REF: 21/03177/F**Location: Axis J9 Phase 3 Howes Lane Bicester**

05 May 2022

Thank you for consulting me on the above application. I have reviewed the submitted documents and crime statistics for the local area. Whilst I do not wish to object to this application, I make the following comments to ensure that the forthcoming application meets the requirements of;

Drawing Title: UNIT 5 ELEVATIONS

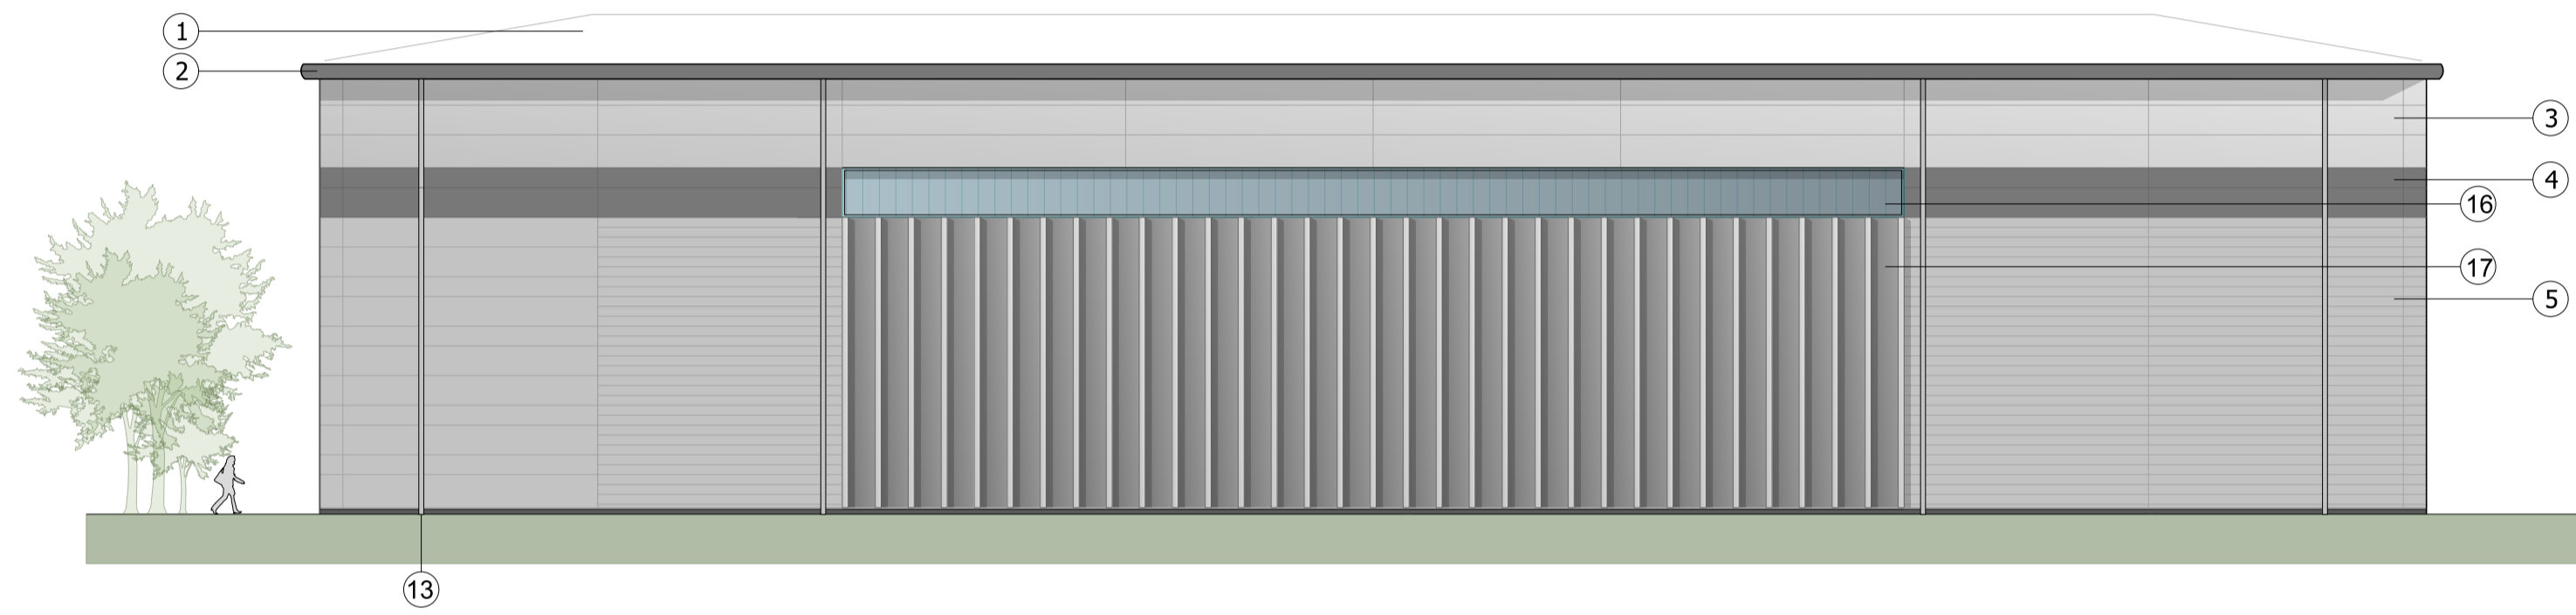
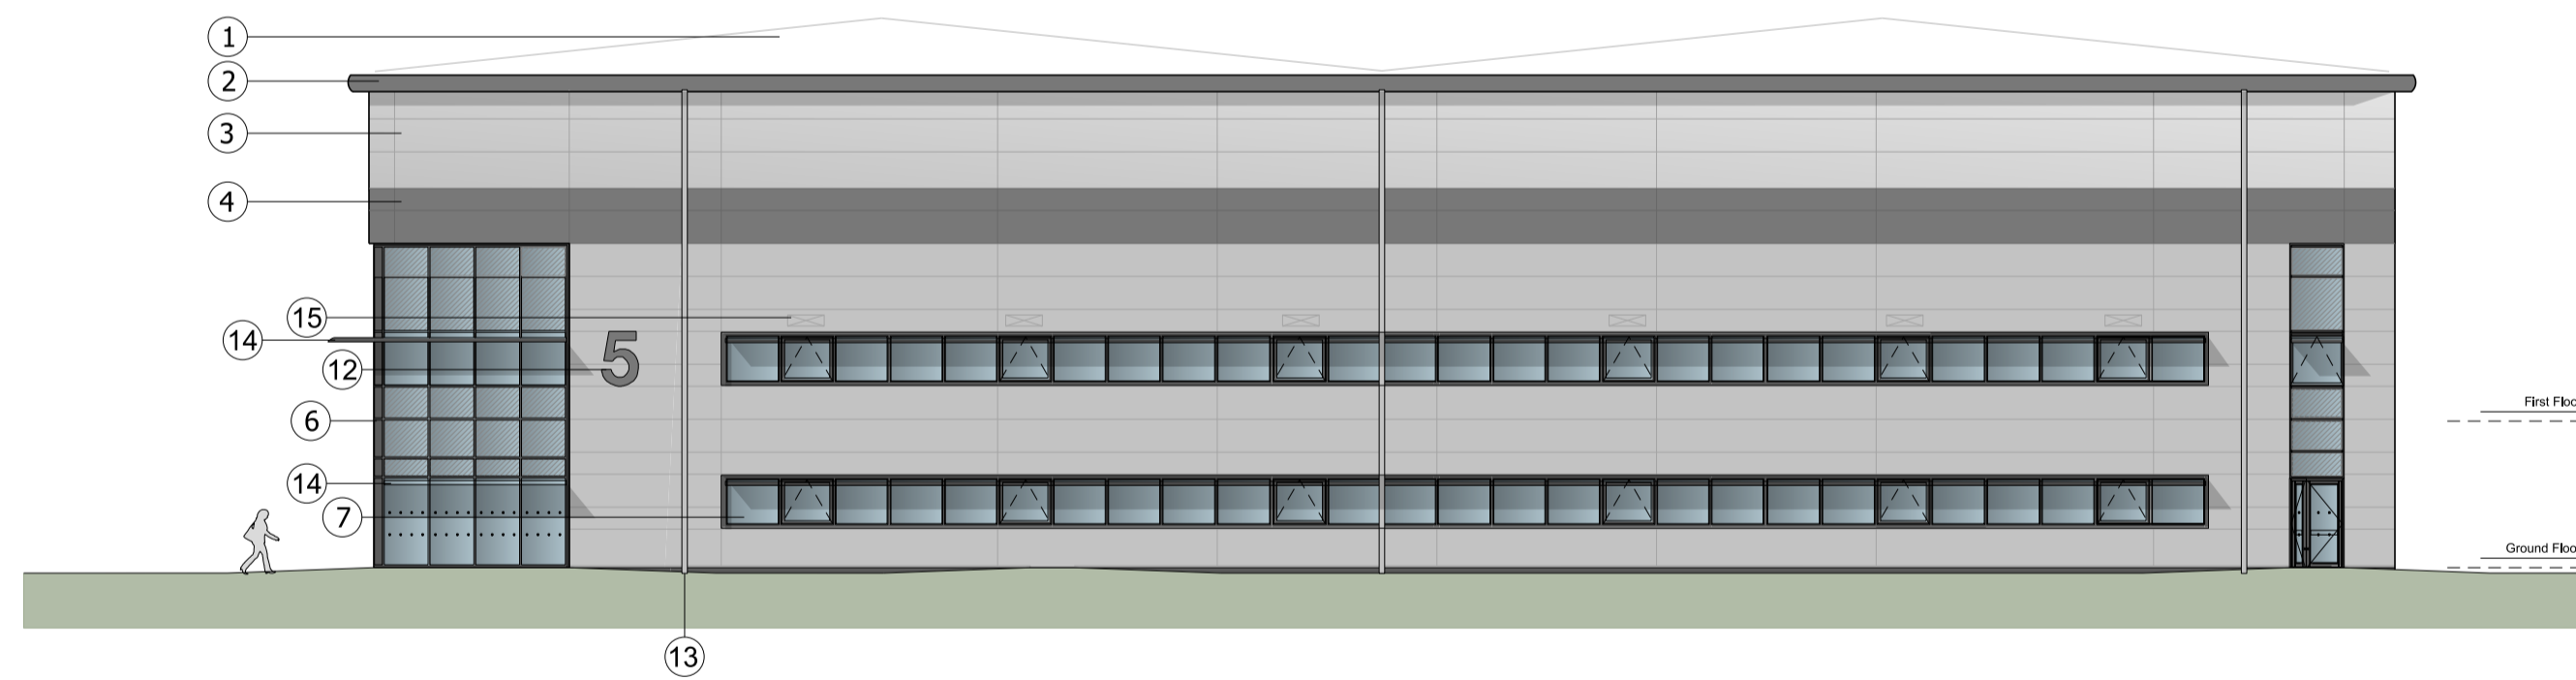
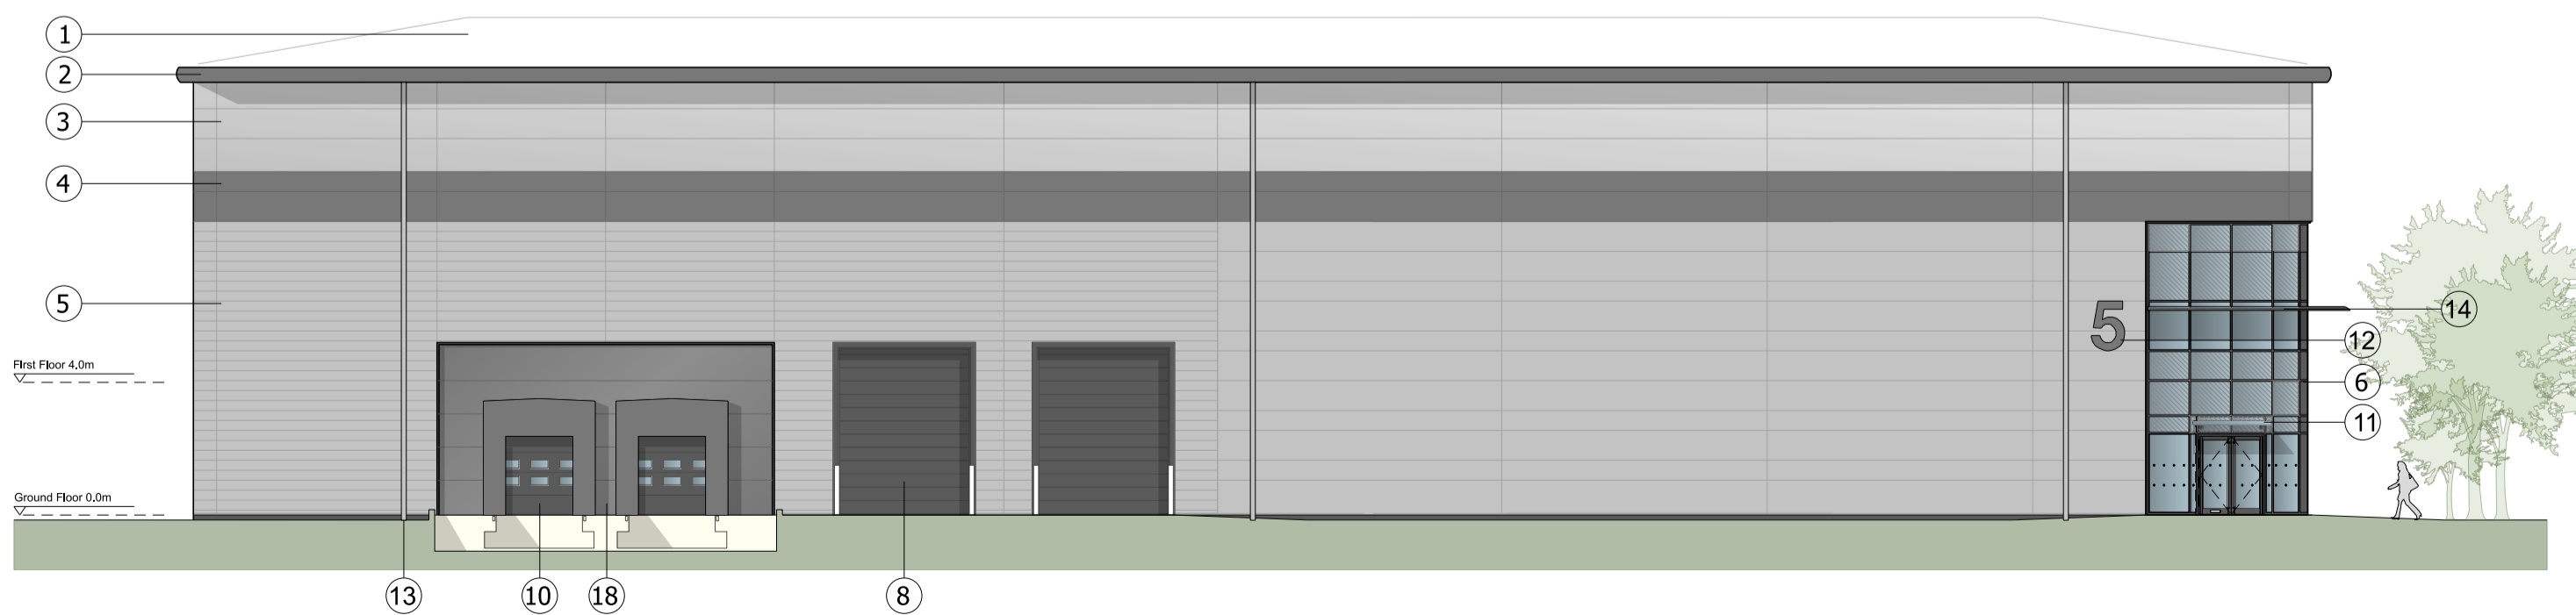
- Roller Shutters – I have been unable to find any details relating to the security of the proposed rollers shutters for 'goods' and vehicular access. These have the potential to leave buildings vulnerable to commercial burglary and should be secured with a roller shutter that meets the minimum standards of LPS 1175 Issue 7 SR 2.

- Doors and windows – Again these should meet the minimum standards of LPS 1175 Issue 7 SR2. Easy to reach and ground floor glazing must incorporate one pane of laminate glass to provide resistance to manual attack to category P1A unless protected via a roller shutter or grille.

- Roof lights – These should be certificated to LPS 1175: Issue 5 or above, Security Rating 2, or STS 202: Issue 1, Burglary Resistance 2.
- Fire escape routes – Plans indicate fire escape doors and paths which are located in vulnerable isolated areas lacking surveillance due to surrounding landscaping and planting. Fire escape routes to the side and rear of units should be enclosed with robust metal fencing to a height of 2m, and be

fitted with secure gates certificated to • LPS 1175: Issue 7, SR 2 or STS 202: Issue, BR2. The gates should be of a design that allows for a line of sight along the side wall of the unit. If the gate requires an emergency release mechanism, i.e. release without the use of a key, it should be protected to prevent operation from the outside of the gate. Anti-climb measures above the gate should be included. I ask that these routes are secured and updated plans submitted to the planning authority and approved prior to permission being granted.
